City of Albuquerque

**Re: Zanios Food Warehouse Addition Phase III Grading & Drainage Plan
Engineer's Stamp dated 9-25-00, (K10/D21A)**

GRADING AND DRAINAGE PLAN

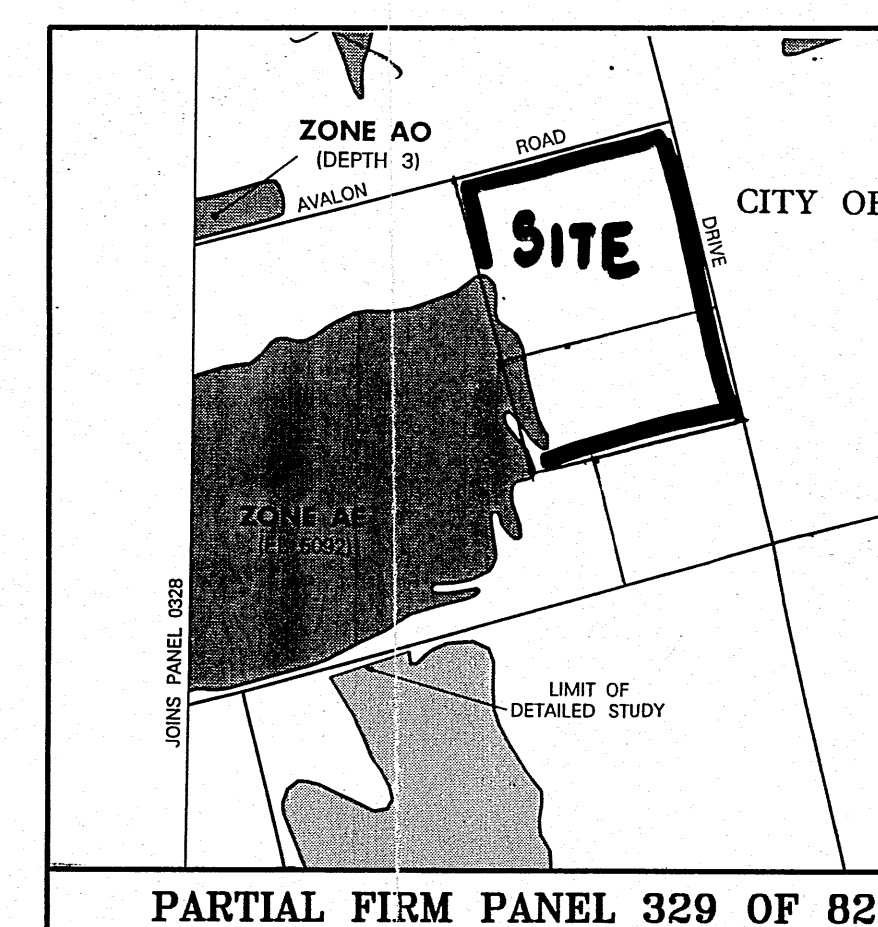
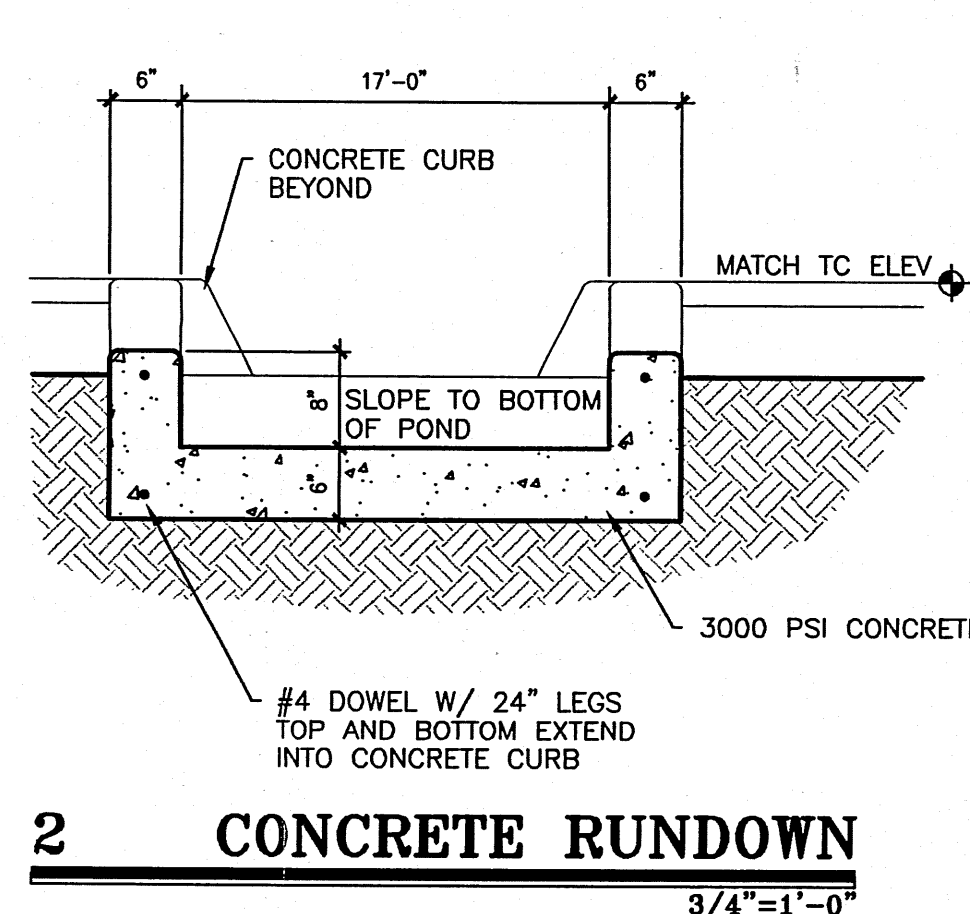
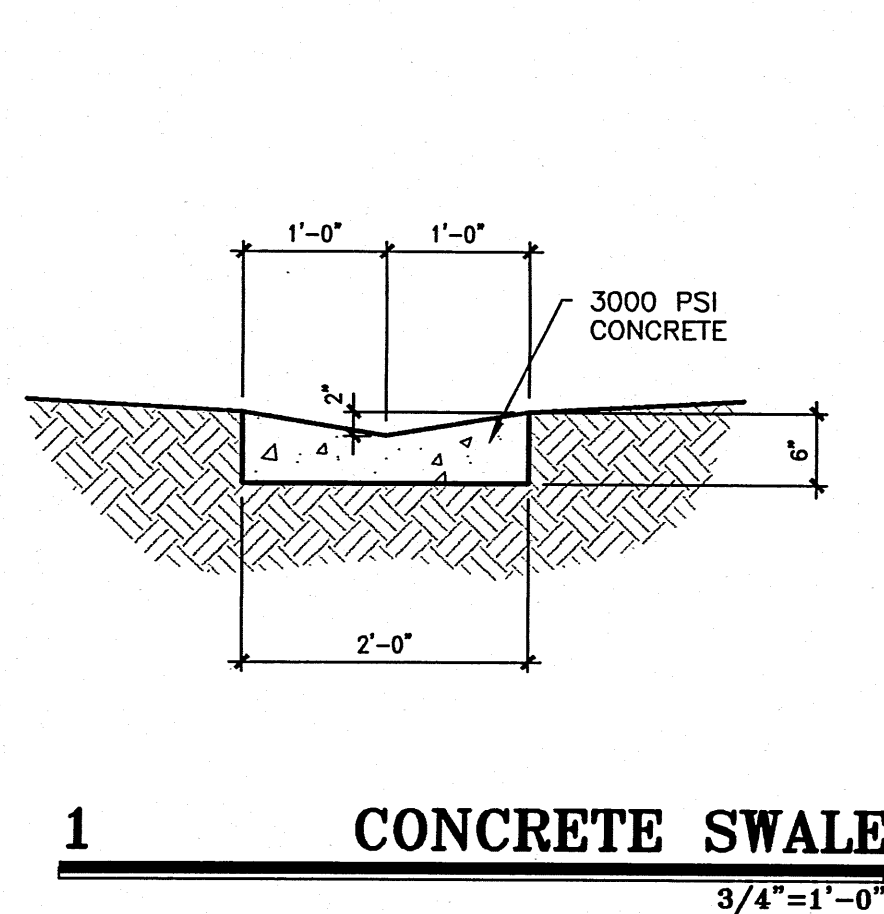
- Please provide calculations for the modification of the standpipe in the existing pond. What elevation are the holes you plan to enlarge?
- Why are the rundowns 17 feet wide?
- What is the proposed treatment around new swale? Asphalt is called out but the detail shows dirt.
- The slab on the south appears to need a retaining wall.
